<b>Application Ref:</b>	3/2021/0586	 <b>Ribble Valley Borough Council</b> <a href="http://www.ribblevalley.gov.uk">www.ribblevalley.gov.uk</a>
<b>Date Inspected:</b>	22/06/2021	
<b>Officer:</b>	AB	
<b>DELEGATED ITEM FILE REPORT:</b>		<b>APPROVED</b>

<b>Development Description:</b>	<b>2 Bridge End Whalley Road Billington BB7 9NU</b>
<b>Site Address/Location:</b>	<b>Proposed addition of window to south elevation, replacement of existing roof lights with larger conservation type velux windows and removal of chimney stack to accommodate internal alterations. Resubmission of 3/2021/0167.</b>

PROPOSED
ELEVATIONS

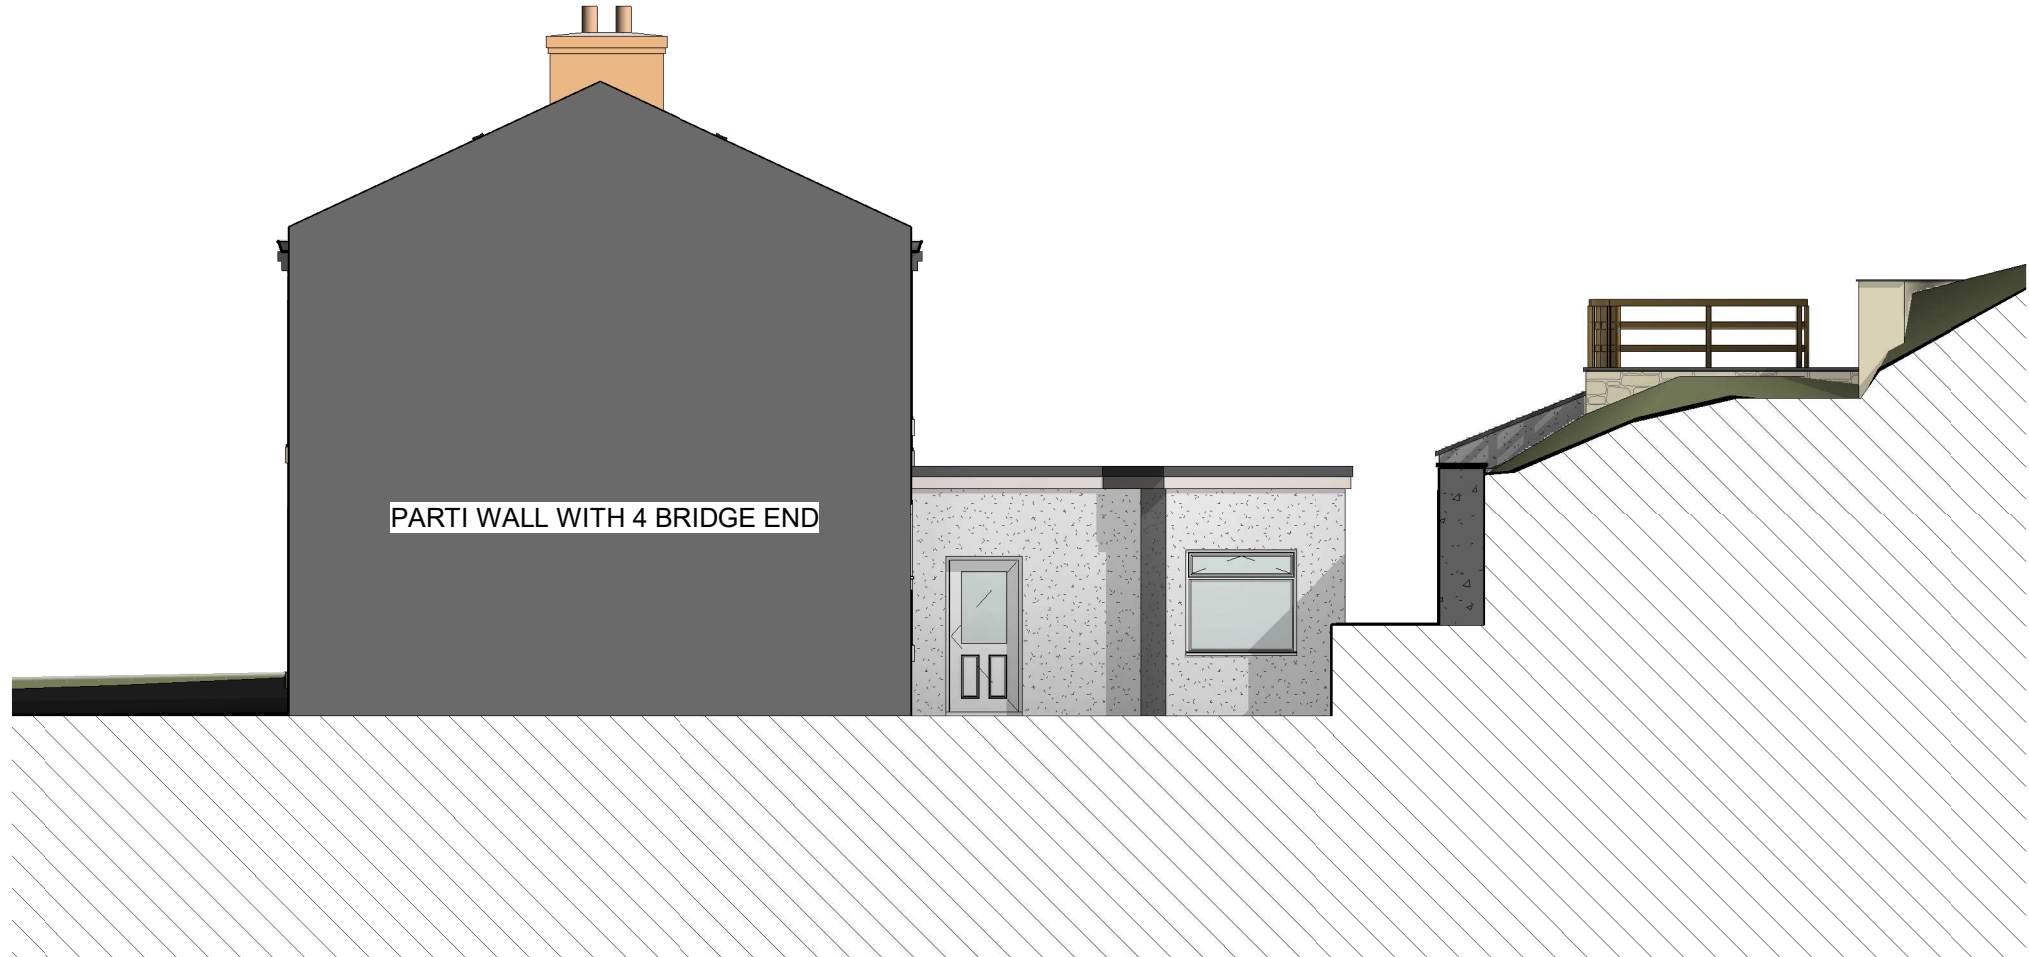
It is considered that the removal of the chimney stack and insertion of new conservation style rooflights would not impact negatively on the appearance of the building or the significance of heritage assets. There are small projecting rooflights present on the front and rear roof slopes as existing and their replacement with flush conservation style rooflights would represent an improvement. The chimney stack would be removed from the hipped roof and in its place an additional conservation rooflight would be installed. This is not considered to be injurious to the character or appearance of the building.

The rear (south) elevation is not visible from Whalley Road but would be seen when travelling north along Moor Lane. The proposed new window on the south elevation would not match the proportions of existing windows, having the same proportions as a doorway opening. This would face directly onto the flat roof of an existing single storey rear extension and could facilitate use of the flat roof as a raised balcony. In addition, it would be good design to ensure that the window respects existing fenestration details. Accordingly, the plans have been revised and the new window now matches existing openings.
